**DESIGN AMENDMENTS STATEMENT
PROPOSED MIXED-USE RE-DEVELOPMENT
23-37 LINDFIELD AVENUE, LINDFIELD, NSW**

The following design amendments have been made in response to the Department of Planning's letter dated 25/02/2011 regarding items that needed to be addressed as a response to submissions received.

Statement prepared by PTI Architects
Peter Israel, Nominated Registered Architect (no. 5064)
April 15, 2011

DRAWING TITLE:  
**SECTIONS SHEET 2**

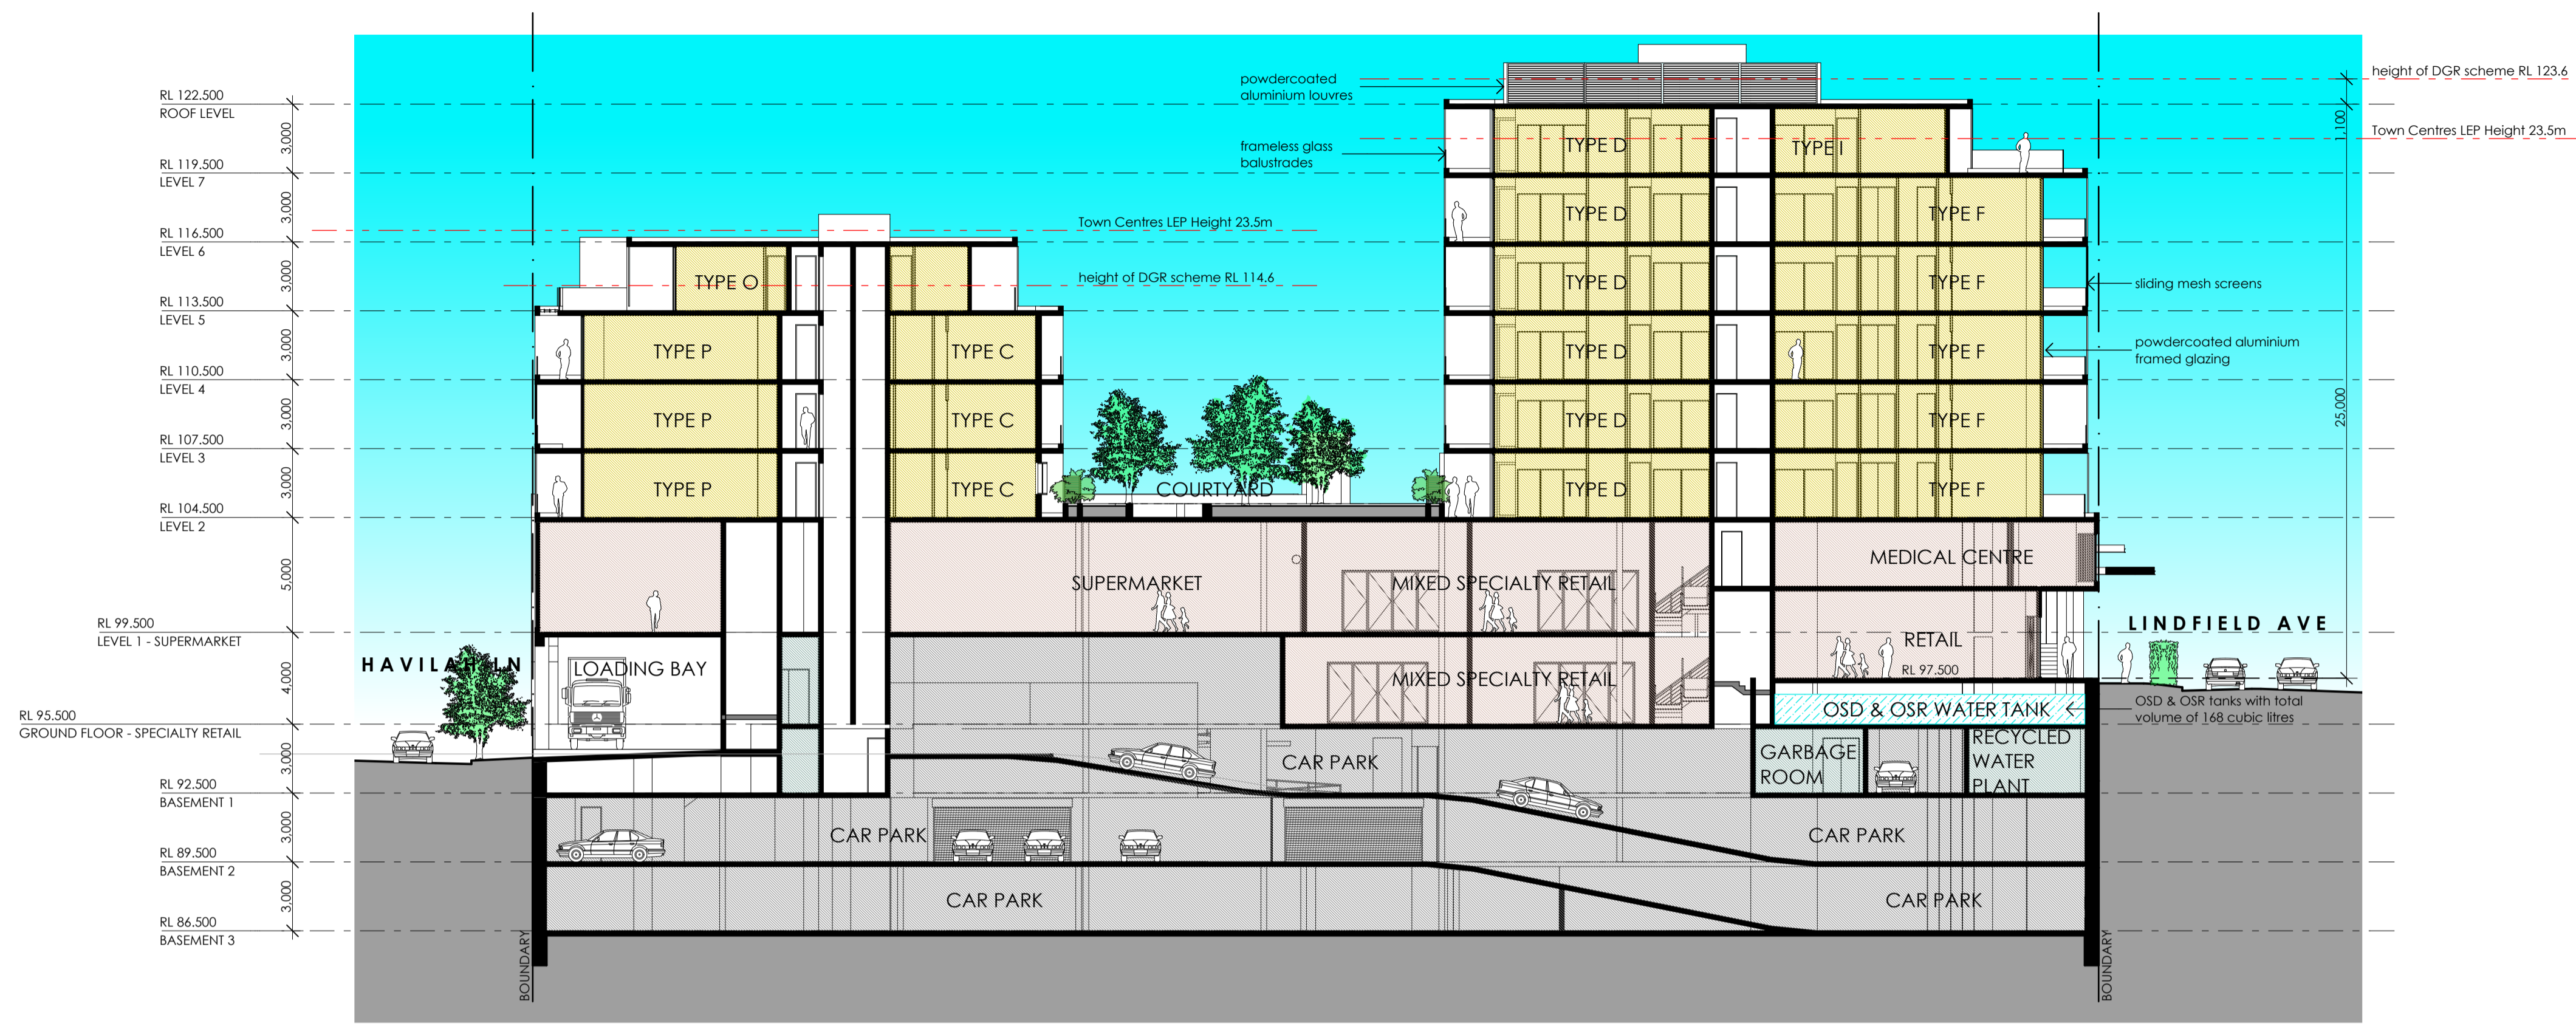
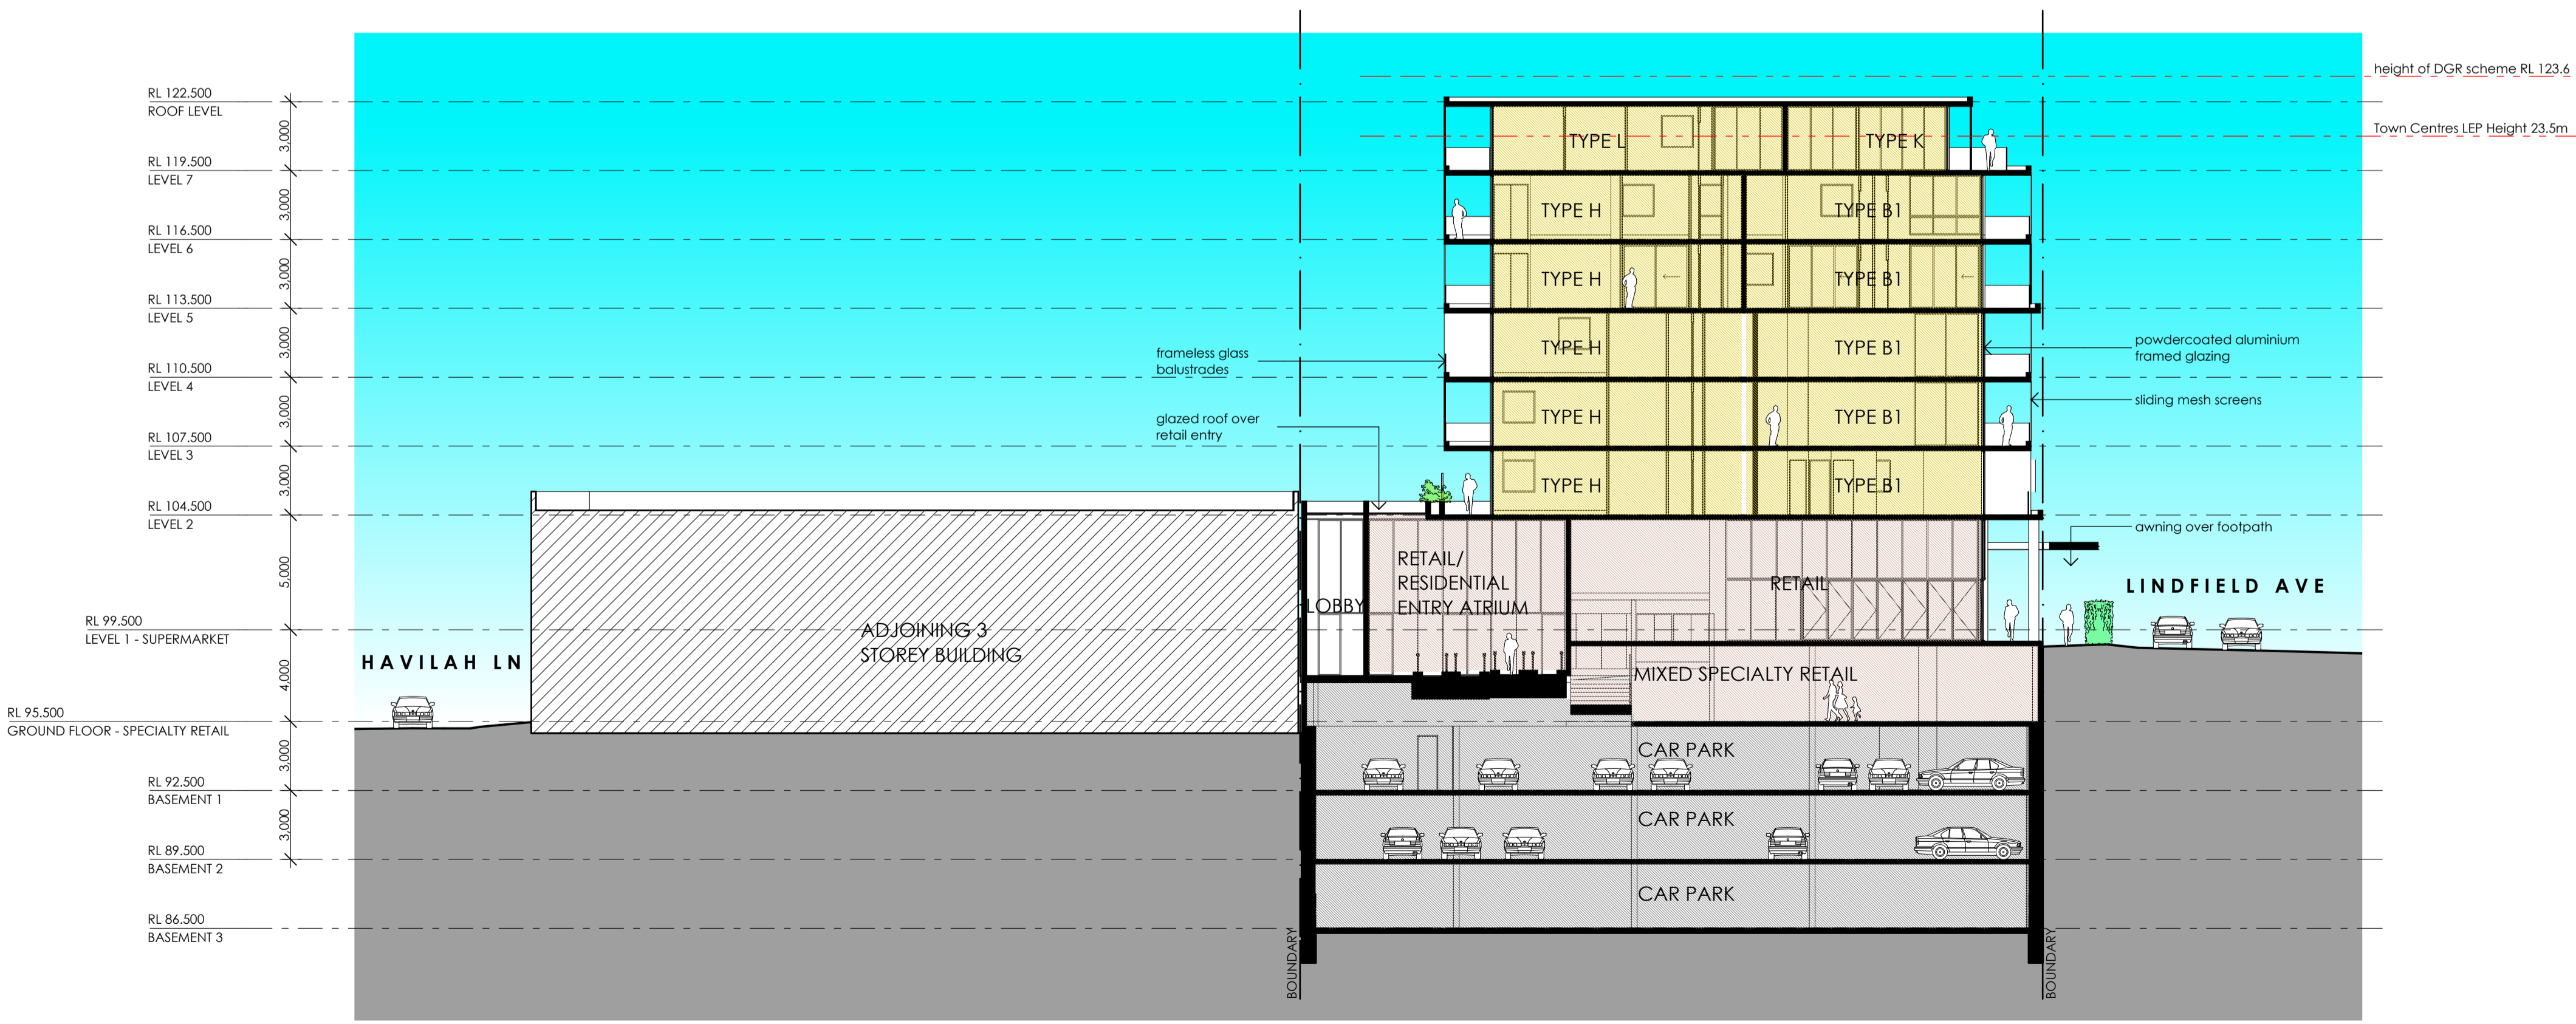
A re-design of the retail levels has moved the supermarket up to level 1 in place of the courtyard and the Level 1 units in Building A. This resolved the issues of retail and residential entry points as well as providing possible future connections for mixed retail at ground floor to the future town square via the corner site at 2 Kochia Lane.

The increase in retail space lifts to communal courtyard to Level 2, with an additional basement level of car parking to cater for additional car spaces.
